Our ref: NO/2021/113355/03-L01
Your ref: 3/2021/0205
Date: 20 September 2021

**ERECTION OF 36 RESIDENTIAL DWELLINGS, ALONG WITH LANDSCAPING AND ASSOCIATED SITE INFRASTRUCTURE.
LAND AT NEDDY LANE, BILLINGTON, BB7 9LL**

Environment Agency position

Proposed Flood Plain Compensation Scale 1:250

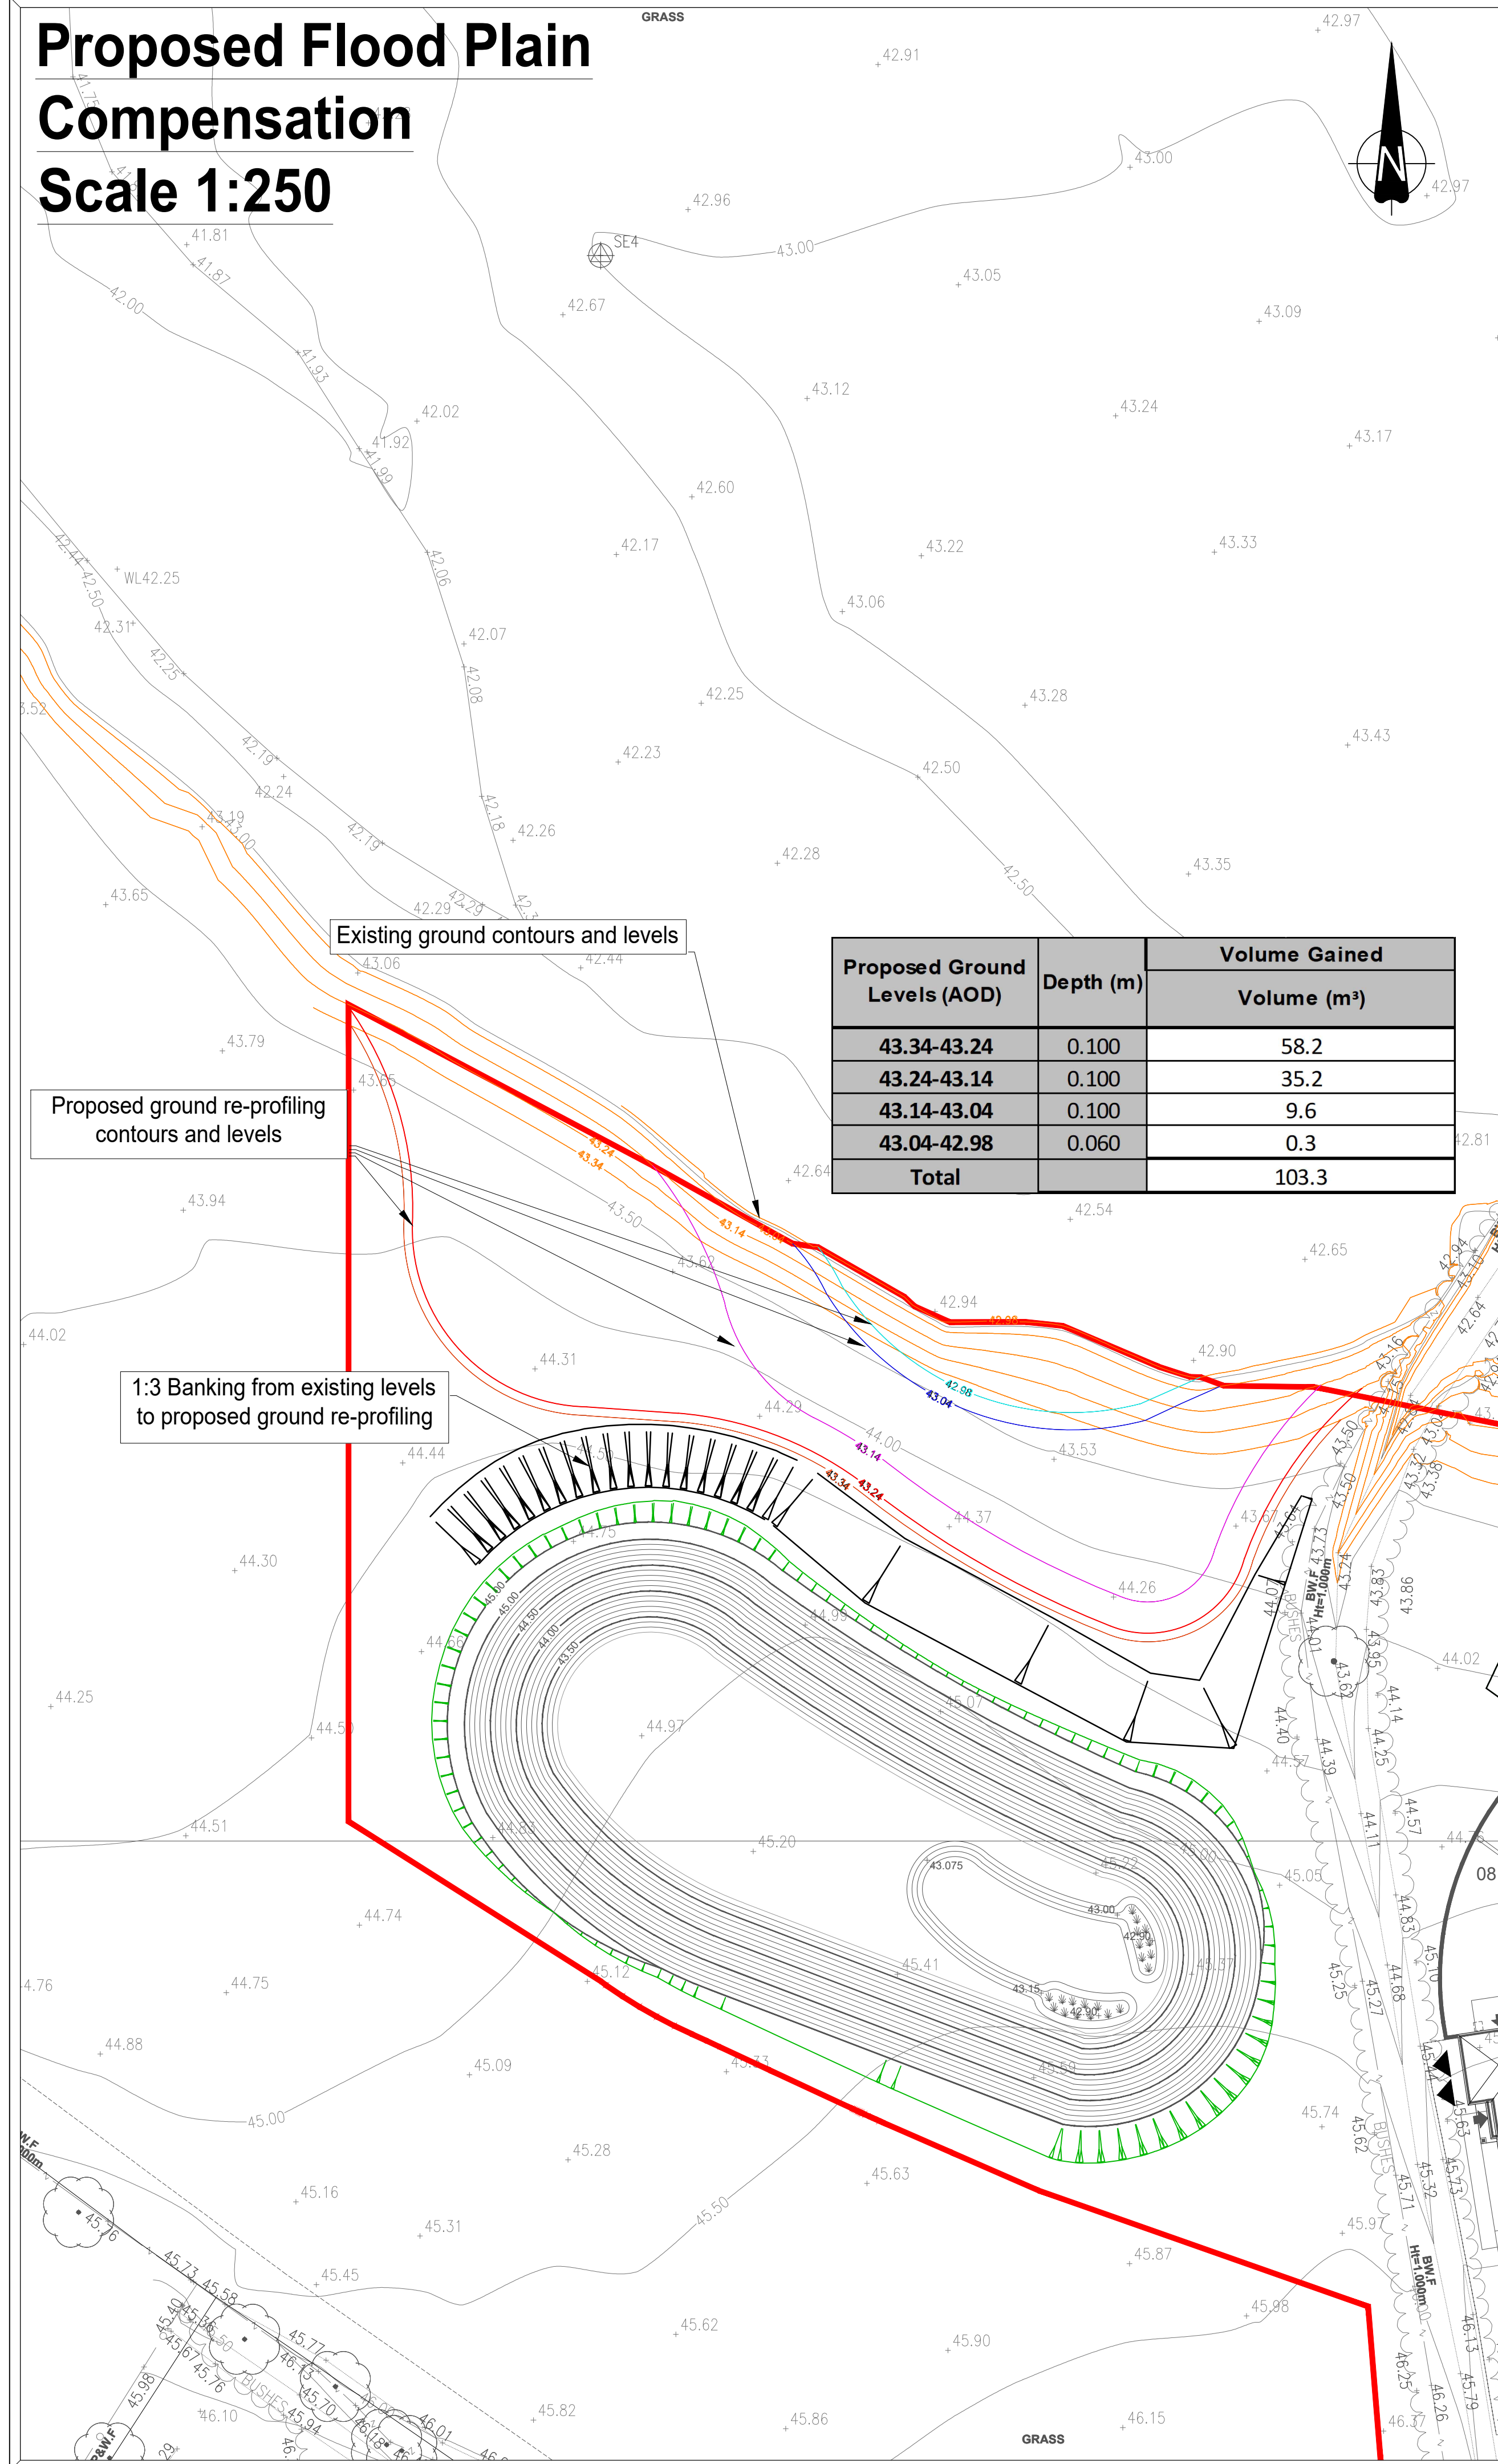
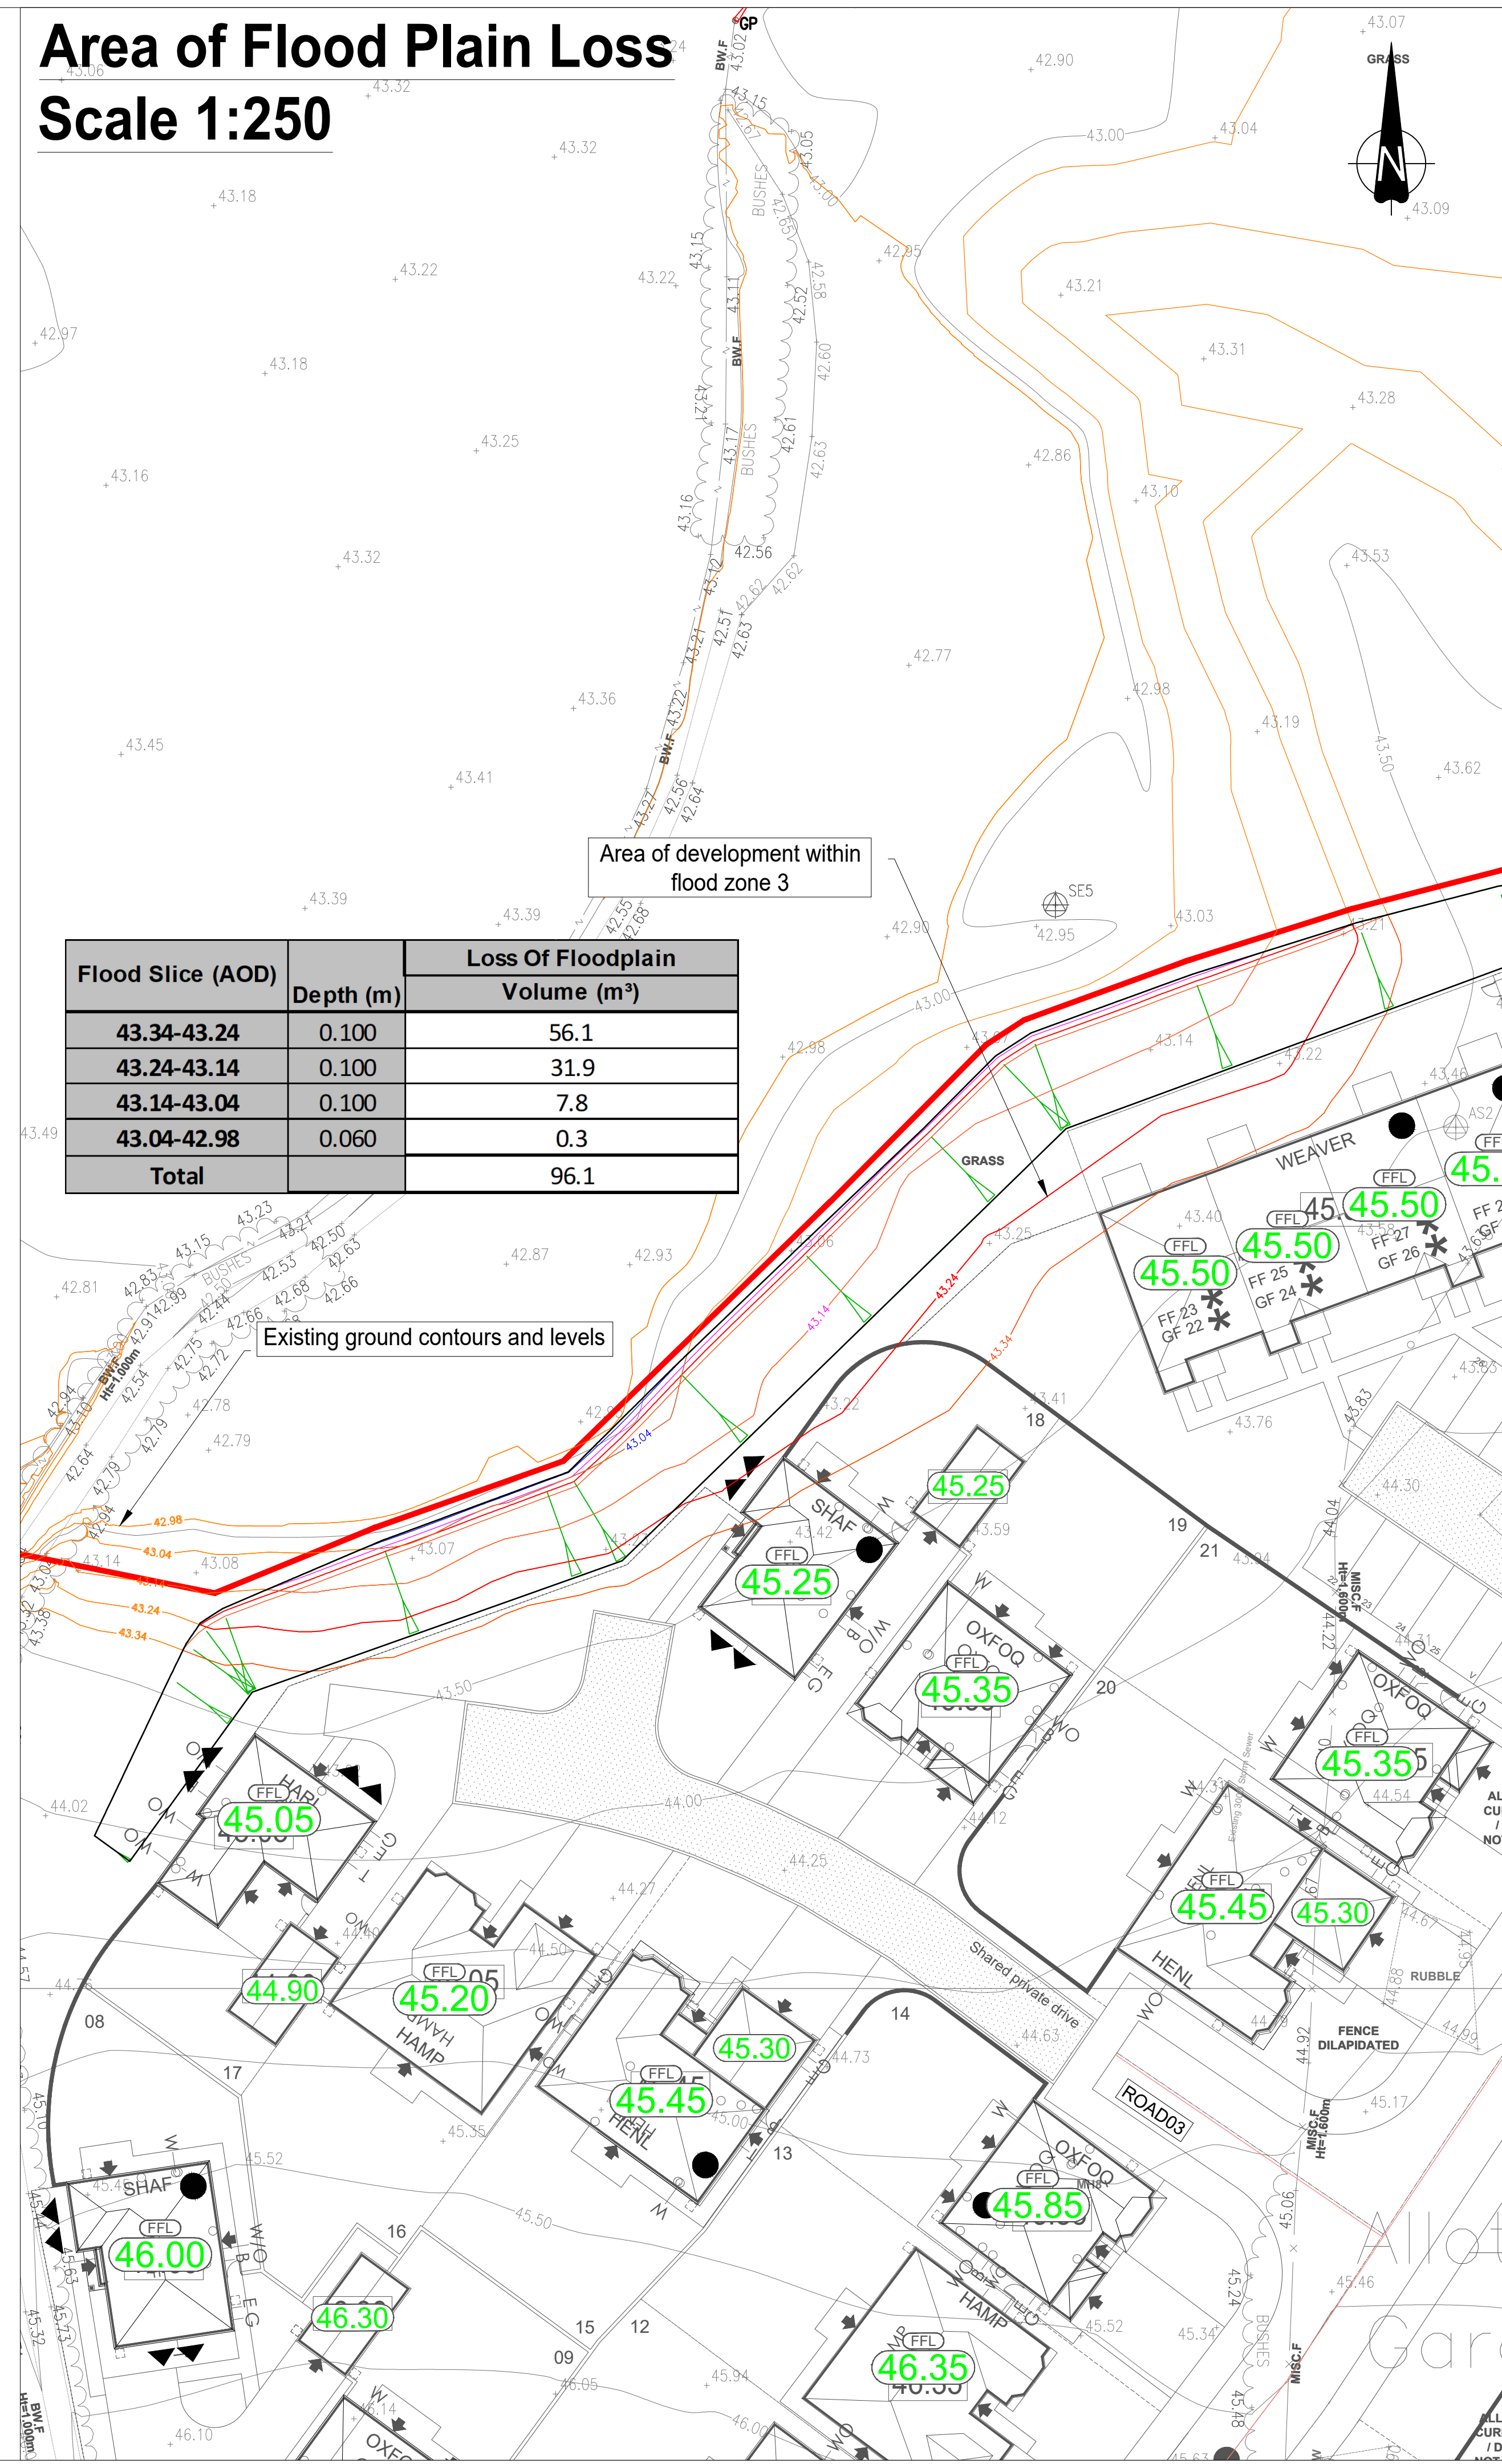
The development scheme proposes increasing ground levels within the 0.1% AEP event. Therefore a compensatory storage scheme has been proposed which results in a marginal betterment in flood storage as shown in drawing 20023-SK07 E, however the proposed design of the scheme is not considered to be acceptable.

The proposed storage area is connected by a restrictive channel design which cuts through an area of higher ground. This connection reduces the hydraulic and hydrological connection to the existing flood plain which the EA does not support. In addition, as flood water drains from the flood plain, sediment often gets deposited. Over time, this deposition would increase ground levels and is likely to result in sediment build up in the narrow channel which would prevent water flowing into the storage area. There is also ground level lowering proposed within the existing floodplain as part of the storage scheme. For similar reasons as above, this is not supported as it is likely that there would be a continuous standing water level, or sediment build up that would reduce the flood plain storage volume.

We would generally encourage where possible, the re-contouring of the land adjoining a floodplain. This is to allow development without increasing, and ideally reducing, overall flood risk.

For schemes such as the one proposed, maintenance must be considered. However, maintenance and the continued regulation of such a scheme is considered to be onerous and the scheme would need to be supported by a maintenance regime, funding and would be likely to need legal agreements to protect the area from future development.

We also request that the applicant provide clarification of whether the proposed SUDs scheme is located within the 0.1% AEP extent and whether ground level raising in this area has been considered in the design of the proposed flood storage scheme. If so, this must also be considered when designing the compensatory storage scheme and the SUDs scheme should not be located within the fluvial flood plain.

To overcome our objection, the applicant should submit a revised FRA which addresses the points highlighted above.
